Tween Bridge Solar Farm

9.4 Statement of Common Ground with the Environment Agency

Document Reference: 9.4

Revision ~~2~~3

### Tween Bridge Solar Farm

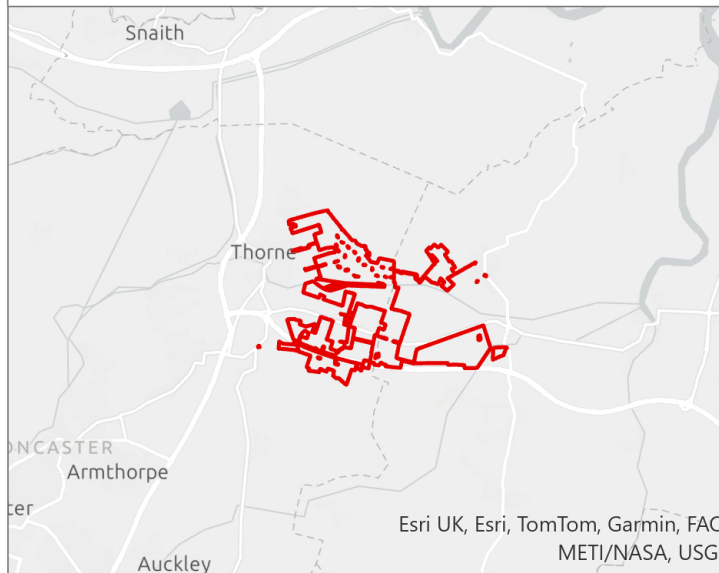
Ref	Topic	EA Position	Applicant Position	Status
			would result in the duplication of this control.	
4.	Ecology and Nature Conservation	The EA is concerned with the number of new culverts proposed (45) and the number of locations (125) where either a new culvert or reinforcement/widening of existing culvert/bridge structures may be required, and the impact of these works for habitats. Further information regarding this is requested together with the implications of this for the EA previously raised concerns regarding the Biodiversity Net Gain Metric watercourse module in relation to culverts. The revised BNG Metric [REP3-Q85Reference unknown] satisfactorily accounts for the proposed culverts in the Watercourses Module, for Biodiversity Net Gain, and what ditch management is required to achieve a 10% net gain.	The Applicant confirms that there are opportunities to deliver enhancements to watercourses across the Order Limits. These measures will include improvements to bankside habitat structure, vegetation management, and measures to improve channel condition. In addition, the cessation of intensive arable practices within the Order Limits will reduce nutrient inputs and physical disturbance to watercourses, which is anticipated to improve water quality and overall condition of aquatic habitats. The Applicant notes that the Relevant Representation provided by City of Doncaster Council (CDC) acknowledges that 'the cessation of agricultural inputs and physical disturbance from ploughing and harrowing will have a beneficial impact on	Under Discussion Agreed

Ref	Topic	EA Position	Applicant Position	Status
		Clarity on Chapter 10: the Water Resources [REP2-021] outlines that <i>Culvert design will be confirmed during detailed design but will ensure the capacity of the watercourses do not change</i>. The EA advises that culverts should be temporary or permanent in nature of culverts is requested together with where possible and that a commitment to fully explore the removal of these culverts at decommissioning stage in order to minimise impacts on morphology and habitats <i>is fully explored post-consent</i>.	water quality', which further supports the conclusions of the assessment. The full metric calculation has been provided by the Applicant to the EA. In relation to the watercourses the current assessment adopts a precautionary approach, with the potential impacts of new and modified culverts, and associated management requirements, have been accounted for within the metric on a worst-case basis where appropriate. The Applicant confirms that any losses or degradation of watercourse condition will be mitigated through targeted enhancements, including new native planting, improved management and the cessation of impacts from agricultural activities. <i>This item is agreed between the parties.</i>
